Mallard Pass Solar Farm

Environmental Statement Volume 2 Appendix 6.3: Landscape and Visual - Consultation Summary

PINS Ref: EN010127

Appendix 6.3 - Consultation Record and Responses Relevant to ES Chapter 6: Landscape and Visual

DRAWING TITLE  
Figure 6.7: Visual Receptor Groups (VRG)  
and Zone of Visual Influence (ZVI), Representative  
Viewpoints and Illustrative Viewpoints

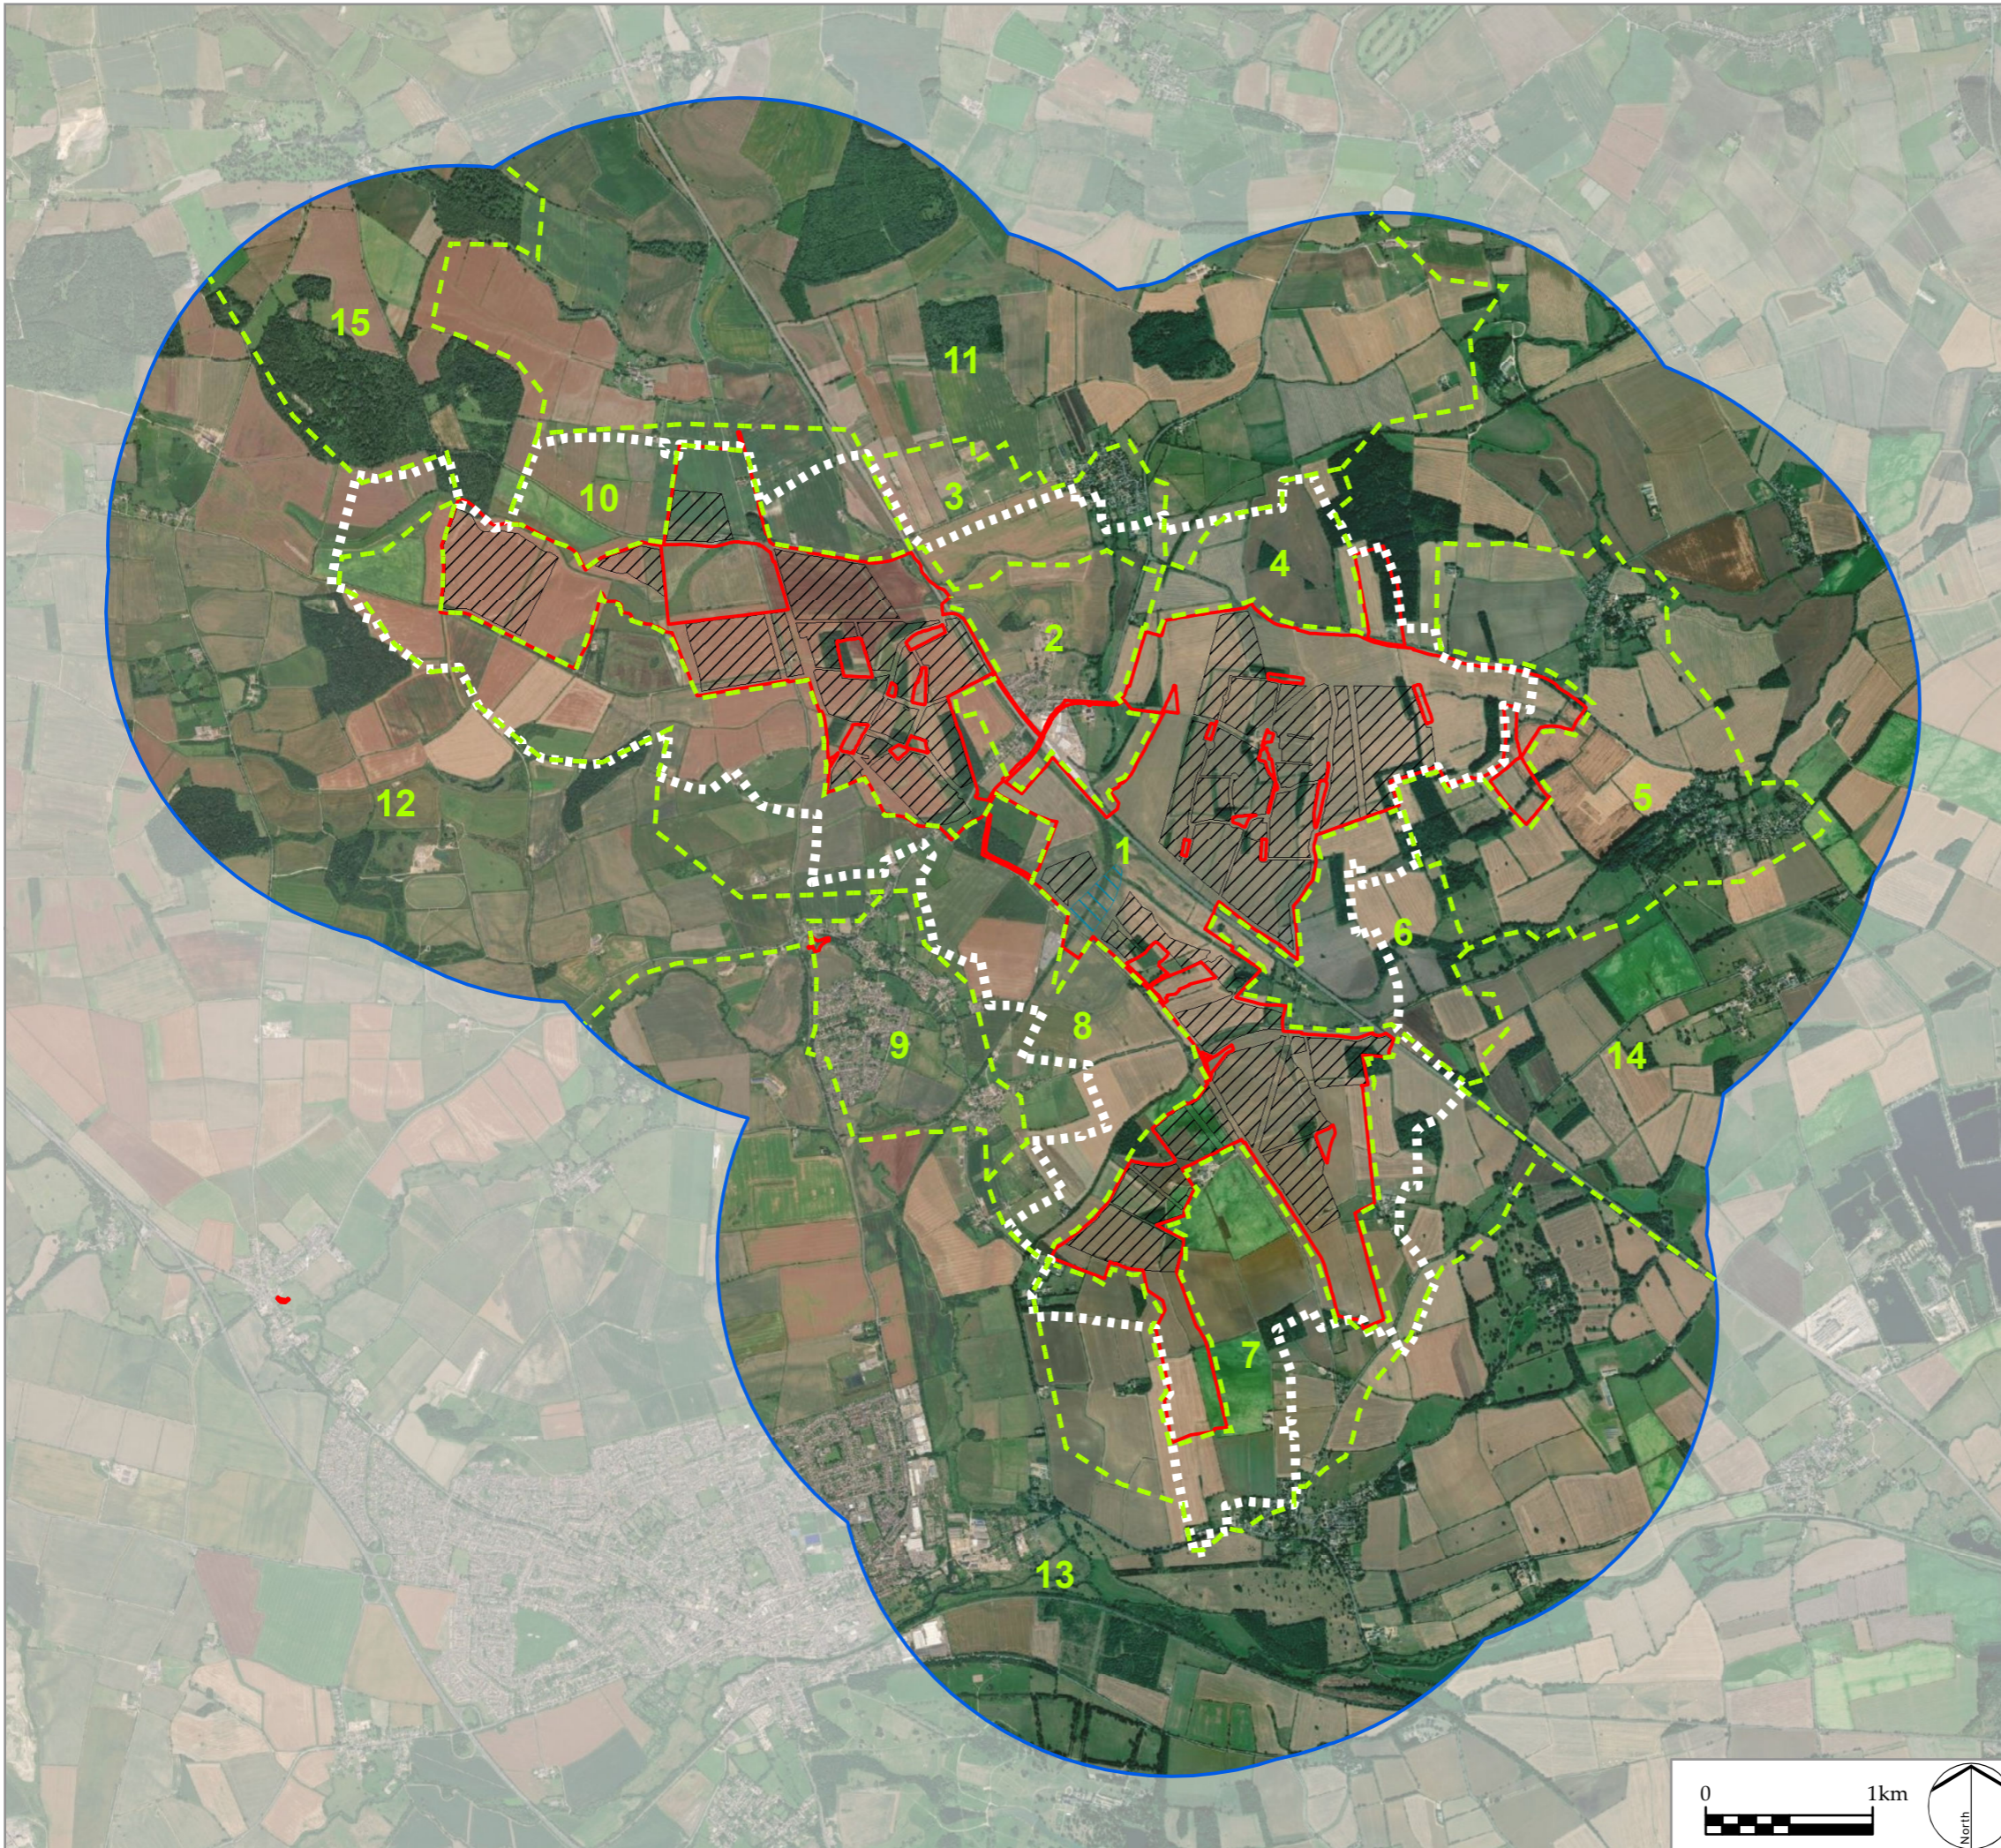
LCC	3 rd August 2022	Figure 6.6, ZTV and Viewpoints Plan – requests inclusion of PRow and additional ZTV's for the solar PV modules and substations on a larger scale plan (approximately 1:25,000 scale).	Figure 6.7 includes the PRow alignments overlaid with the ZTV. The ZTV Plan has been enlarged to read at 1:20,000 at A1 / 1:40,000 at A3.	ES Chapter 6, LVIA - Figure 6.7
LCC	3 rd August 2022	Figure 6.7, Zone of Visual Influence and Visual Receptor Groups – requests a further	The Zone of Visual Influence (ZVI) within Figure 6.7 reflects the application Solar PV	ES Chapter 6, LVIA - Figure 6.7
